SANDSTONE PRECINCT

DESIGN REVIEW PANEL - ADVICE 10

4 October 2019

EDUCATION BUILDING

Substation proposal

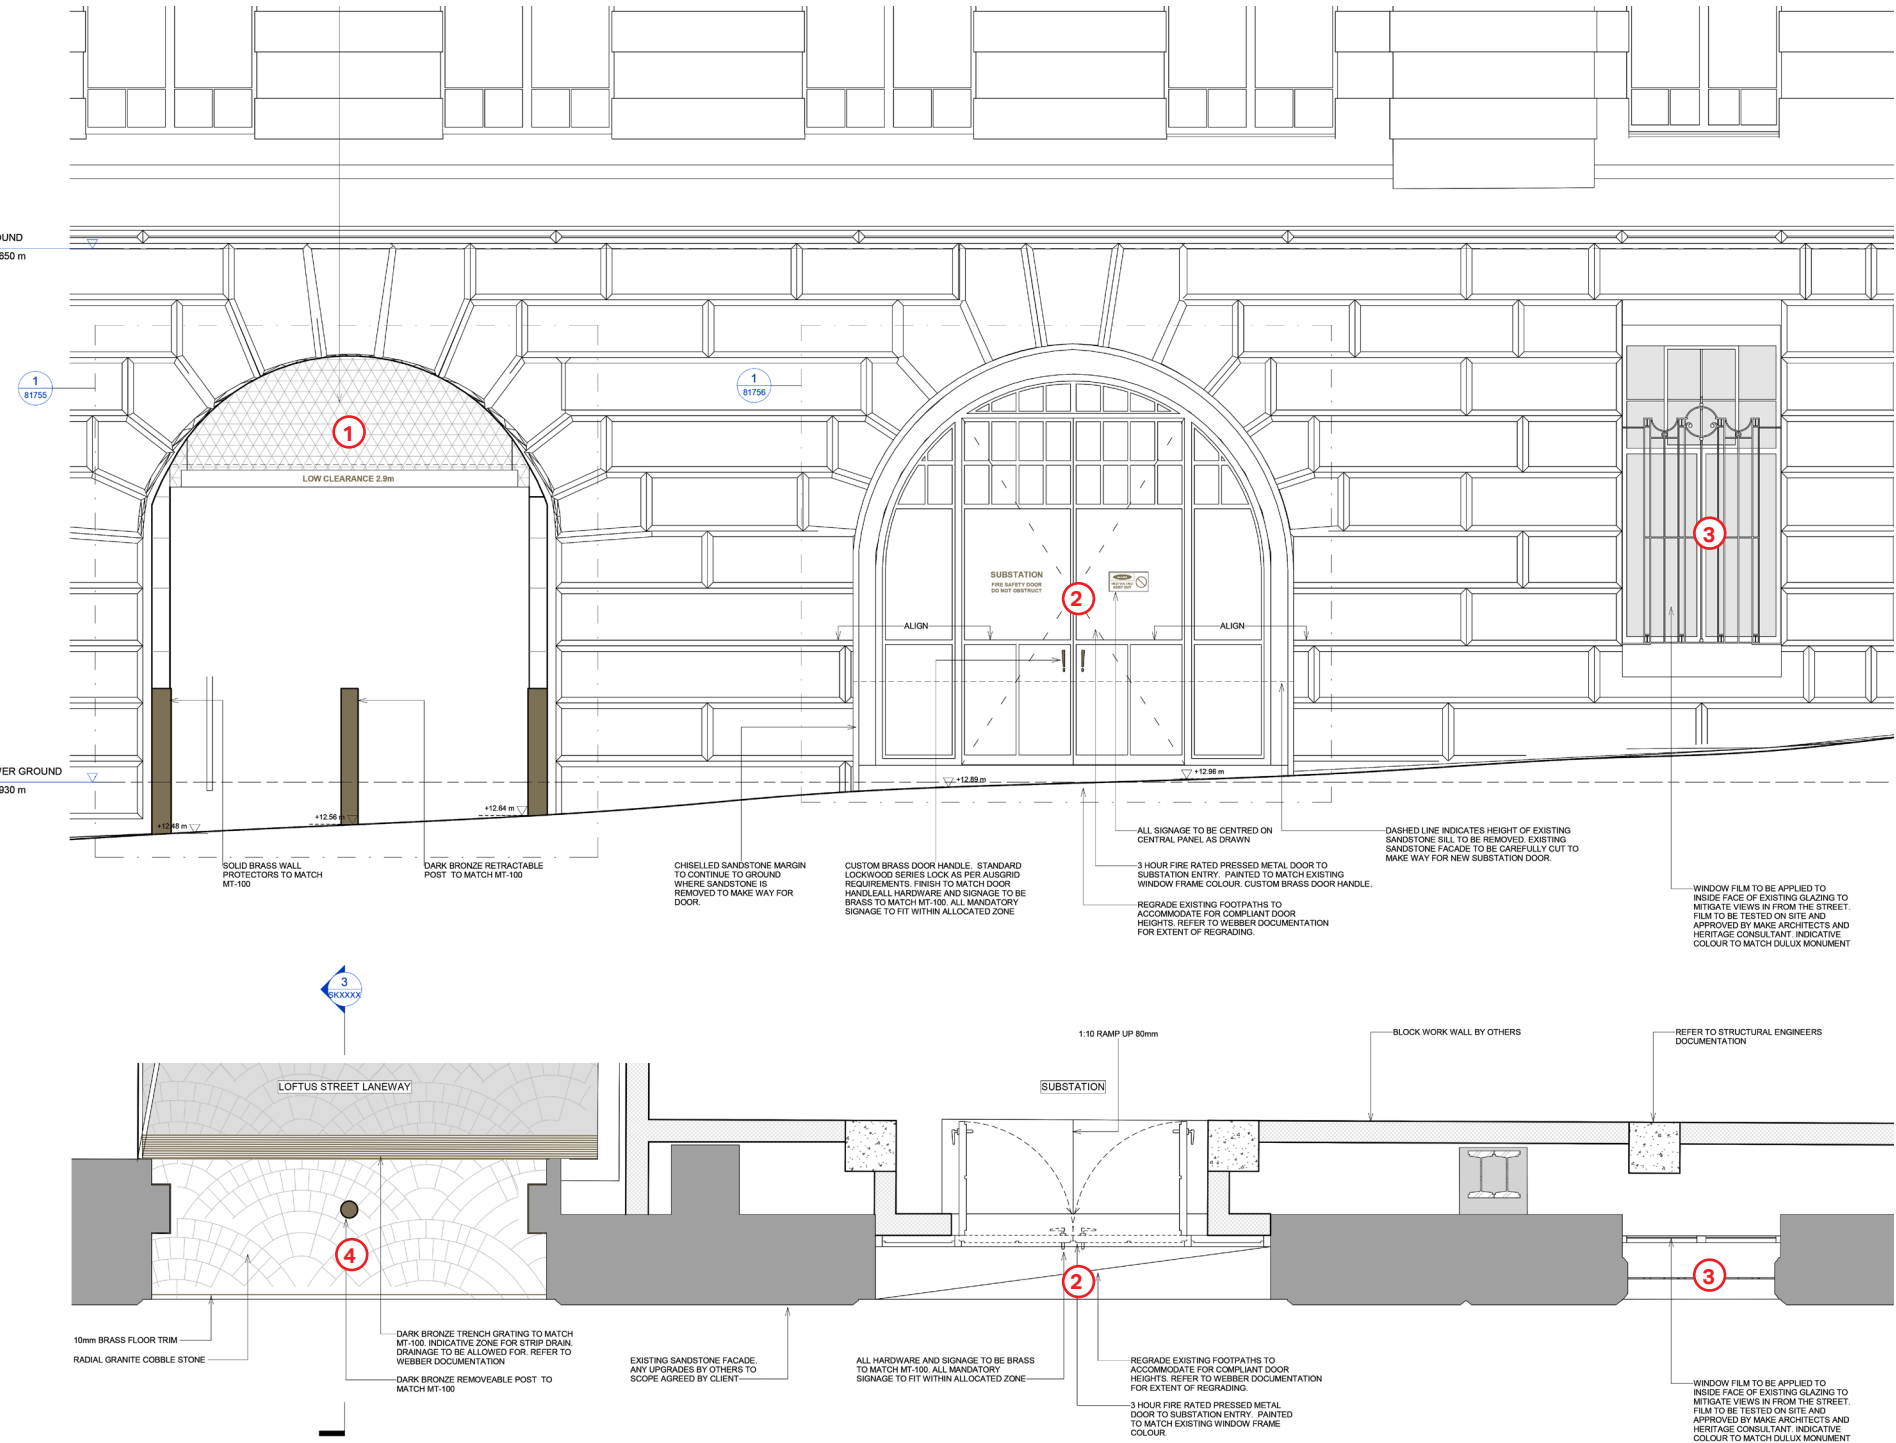
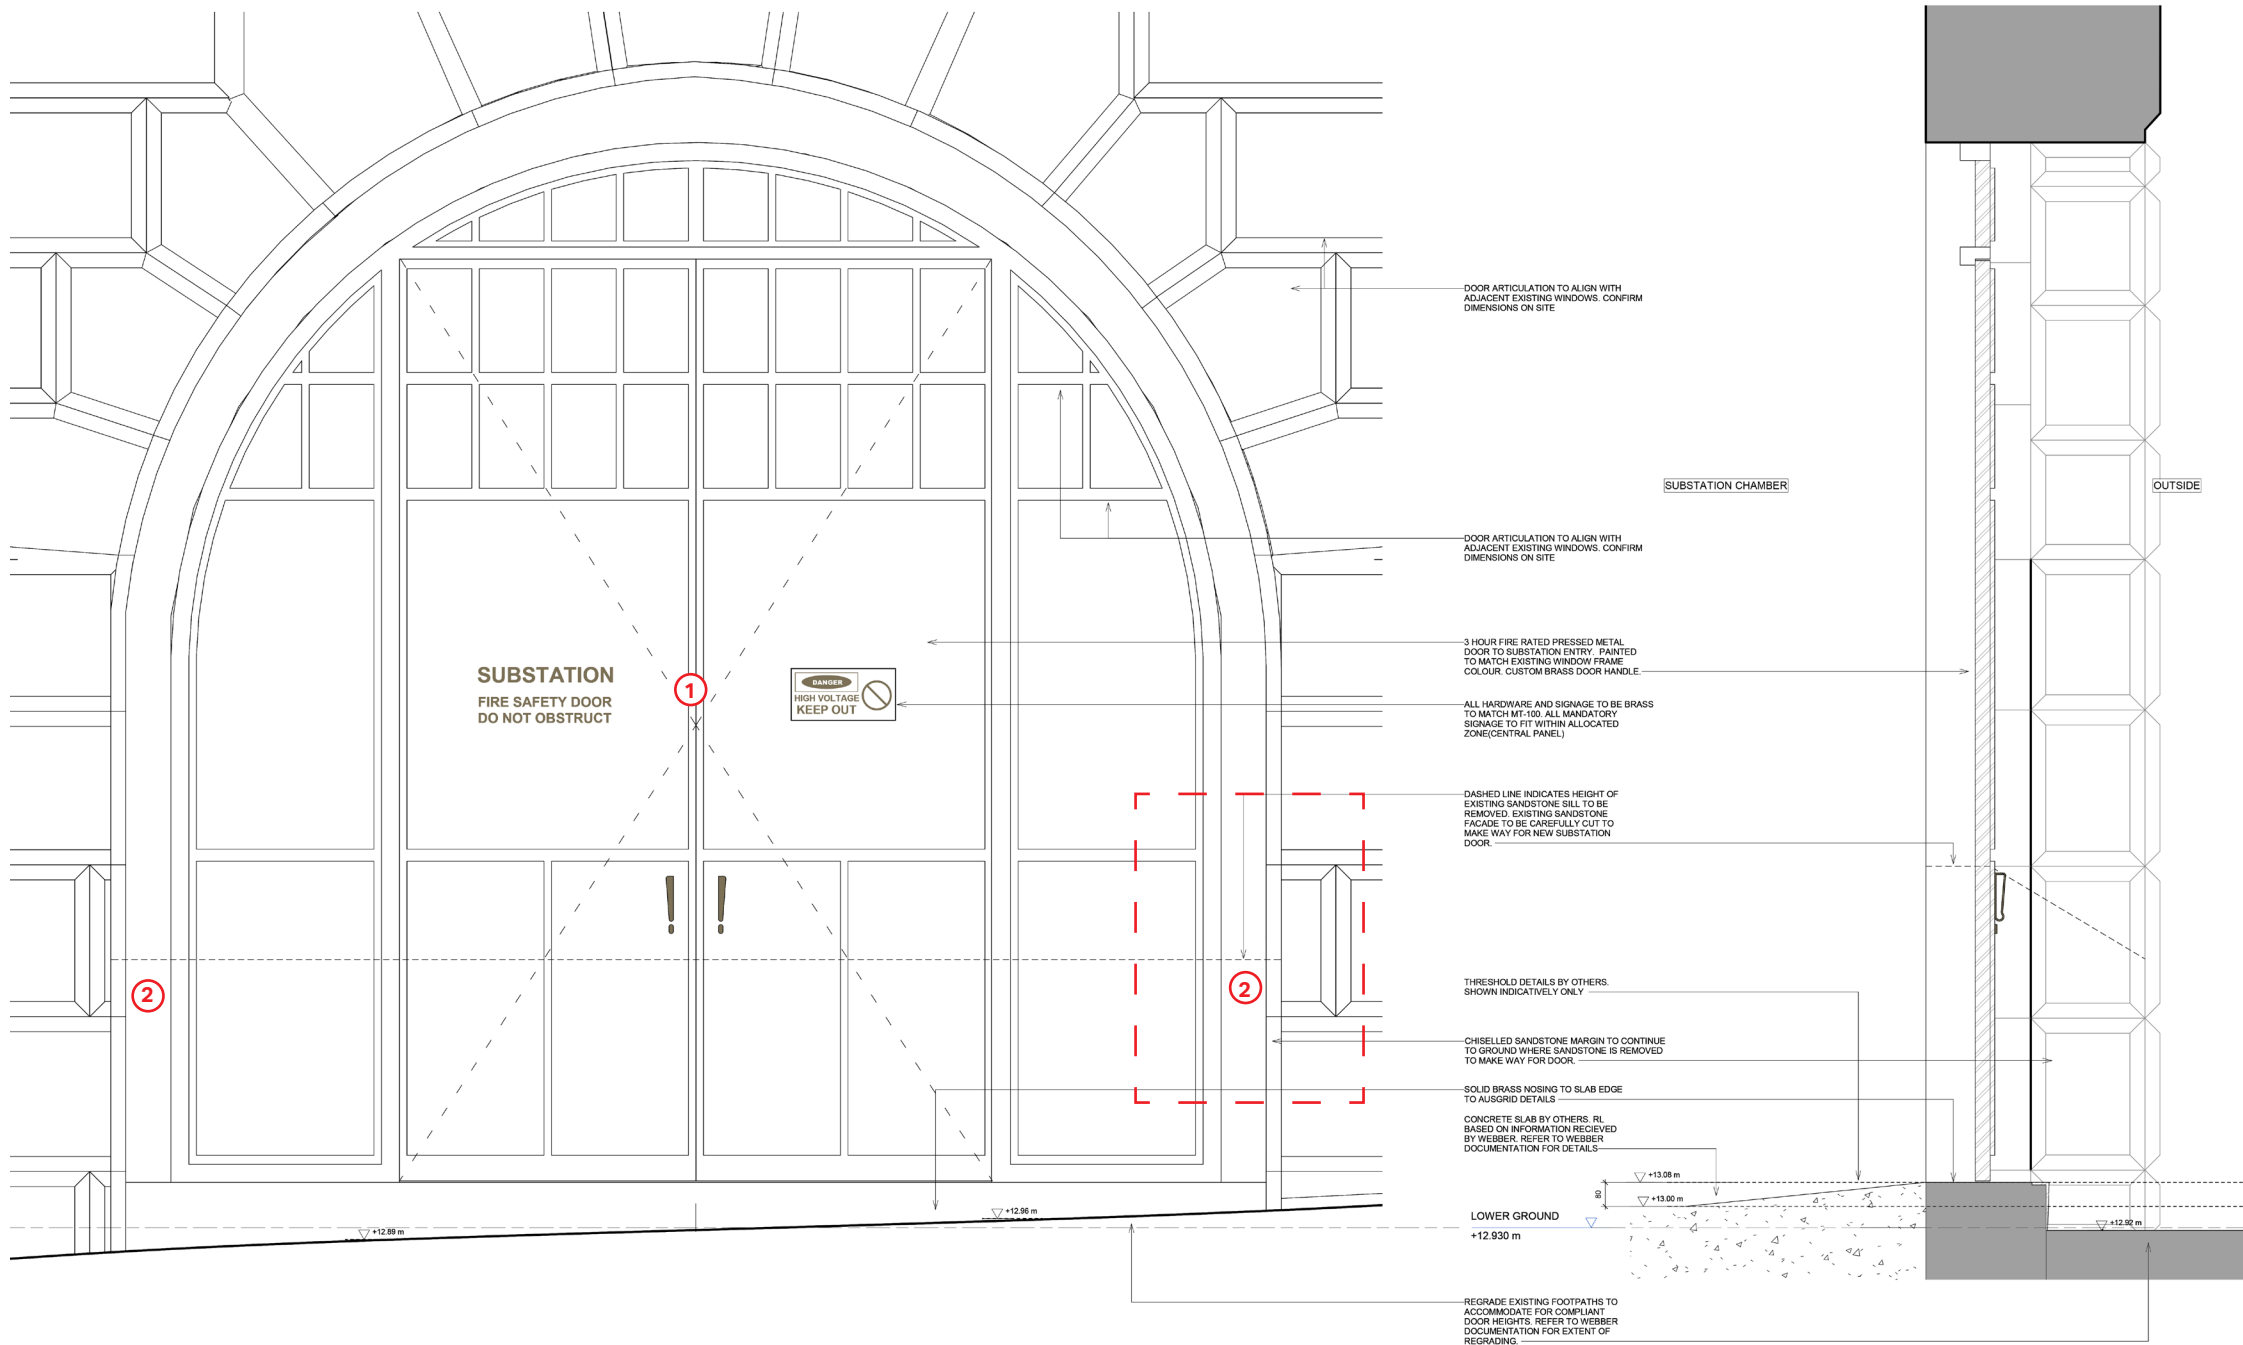
The Panel notes the restrictions in the placement of the substation under Farrer Place, and accepts the proposed relocation and associated changes. It would like to see the resolution

of the proposed changes to the openings in the sandstone façade and their detailed treatment, before sign off.

The Panel notes the proposed treatments to the substation external openings and supports the strategy; subject to inspection of samples for "the new custom perforated screen", and finally agreed finishes with Ausgrid. Should the agreed finishes change the Panel requests review of the agreed proposal.

Loftus Street laneway entrance

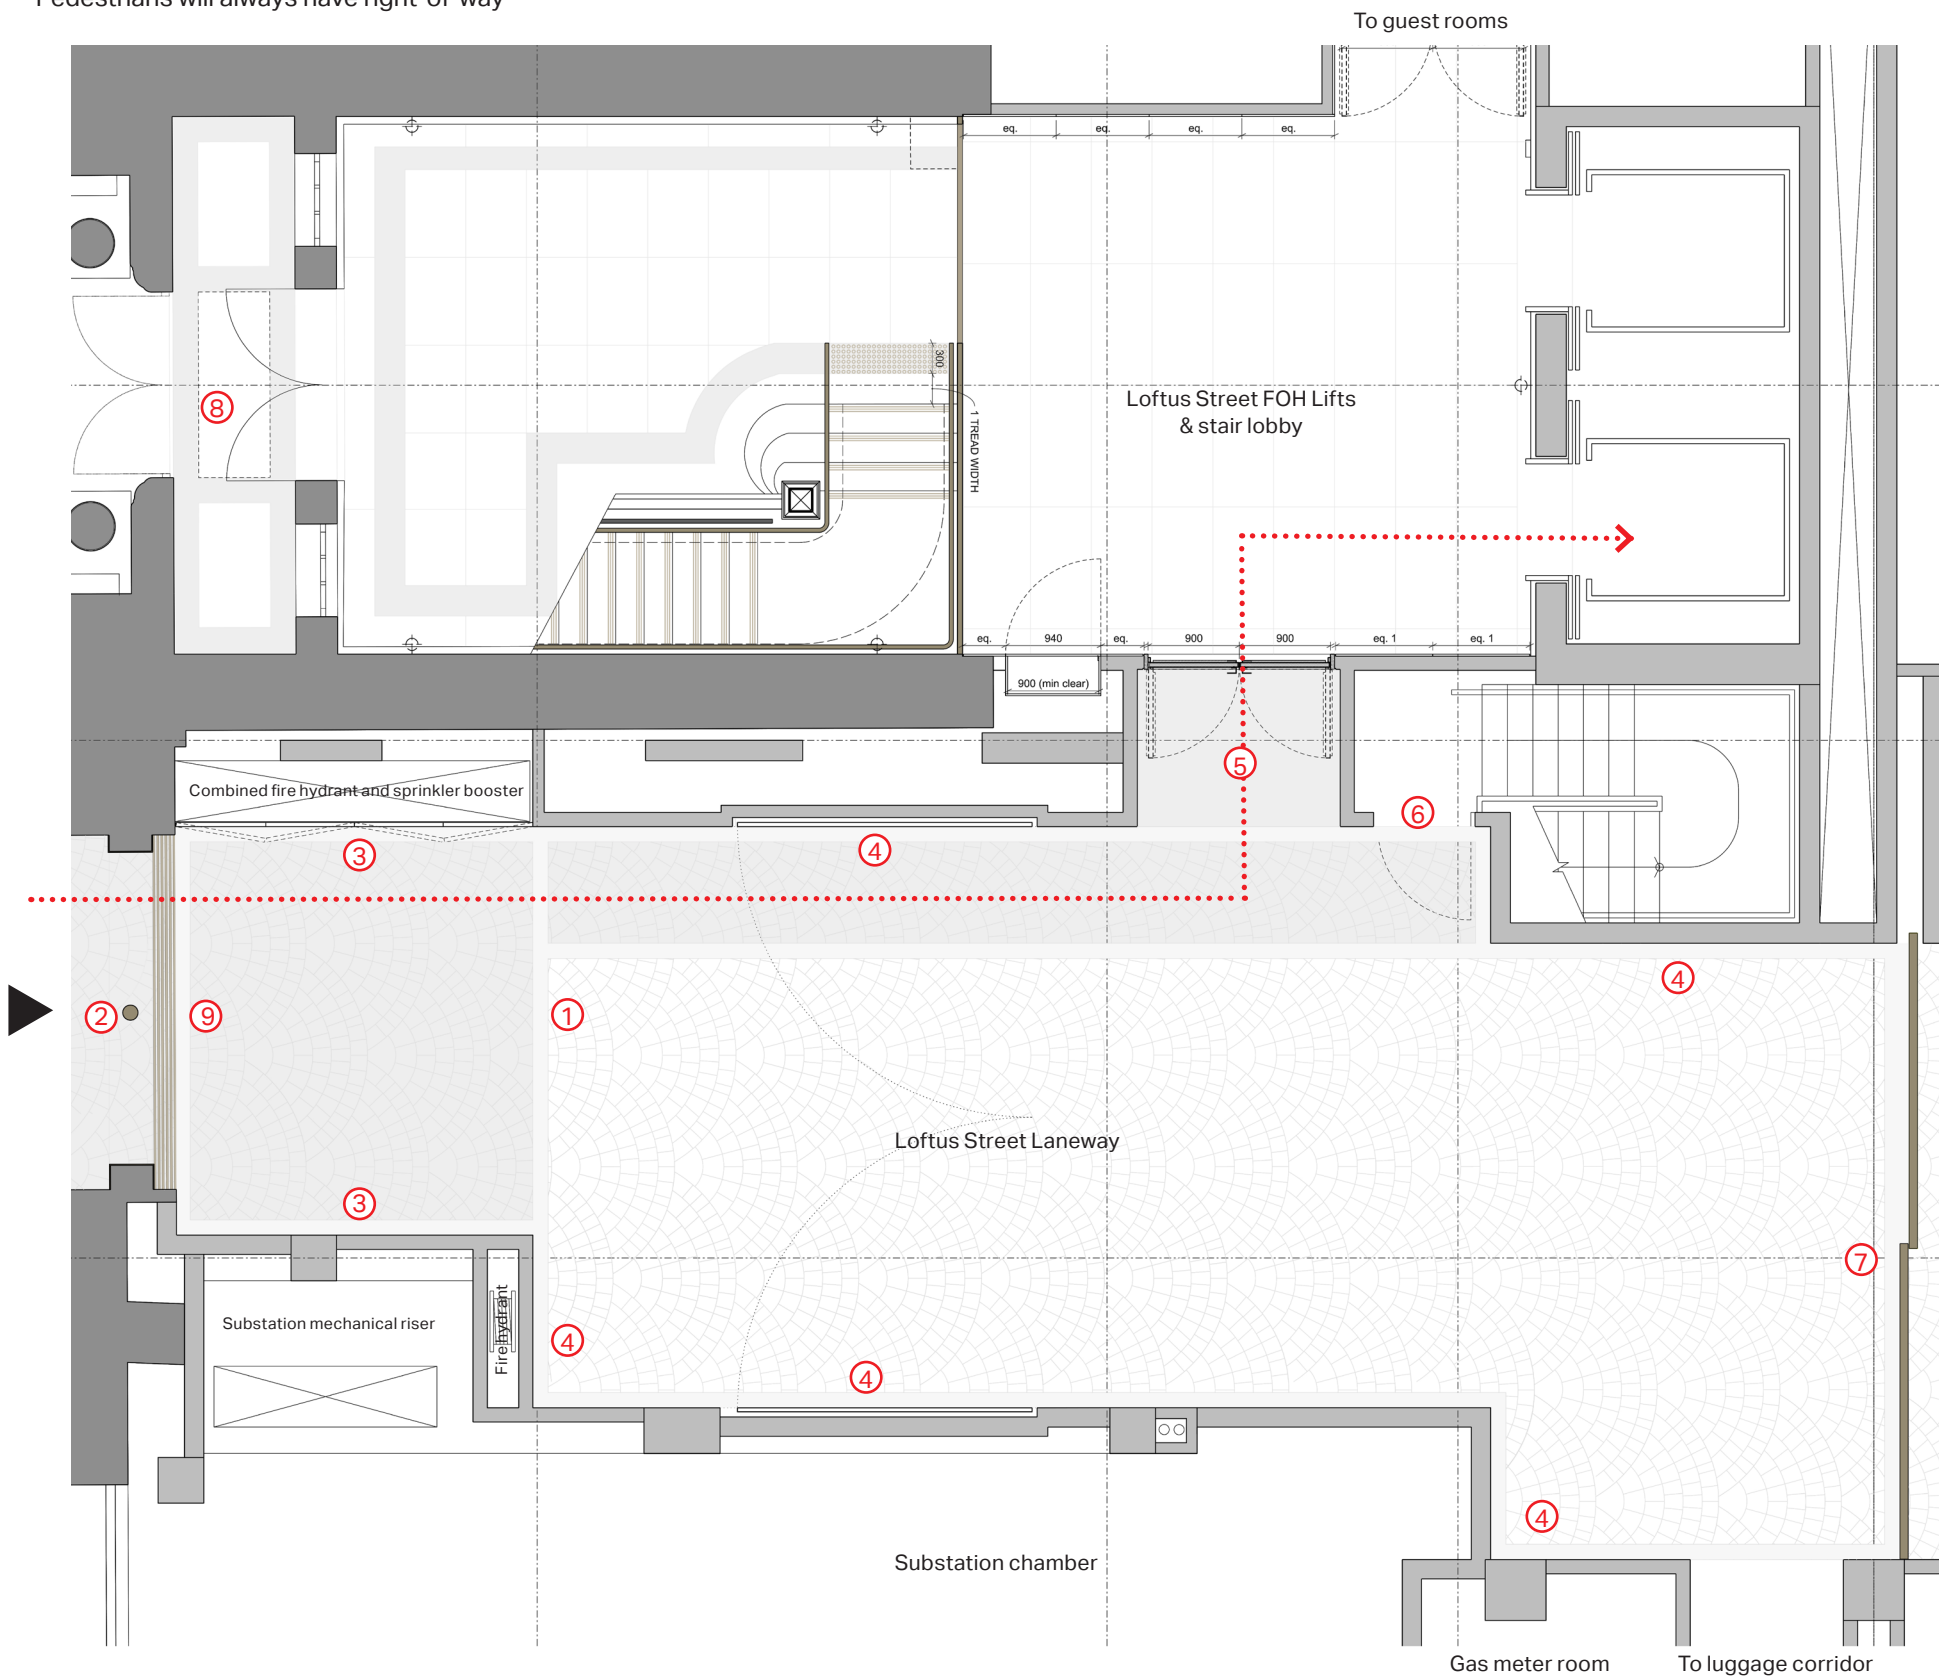
The laneway entry will now serve the multiple functions of public entry, accessible entry and service entry. The proposal to use high quality finishes is supported but more detail is required about how the proposed materials all come together. Elevations or renderings showing this are required, more than reference sample photos.

The proposal to use high quality finishes is supported but there remains ambiguity between the drawings and the rendering, The rendering shows timber cladding to the service cupboards and entry to the lobby but is unresolved for finishes to the wall in between (north face). The plan also shows a large swing door recessed into this face, and to the east a metal (unspecified?) door with "etched fish scale pattern". It is difficult to put all these together as a design package.
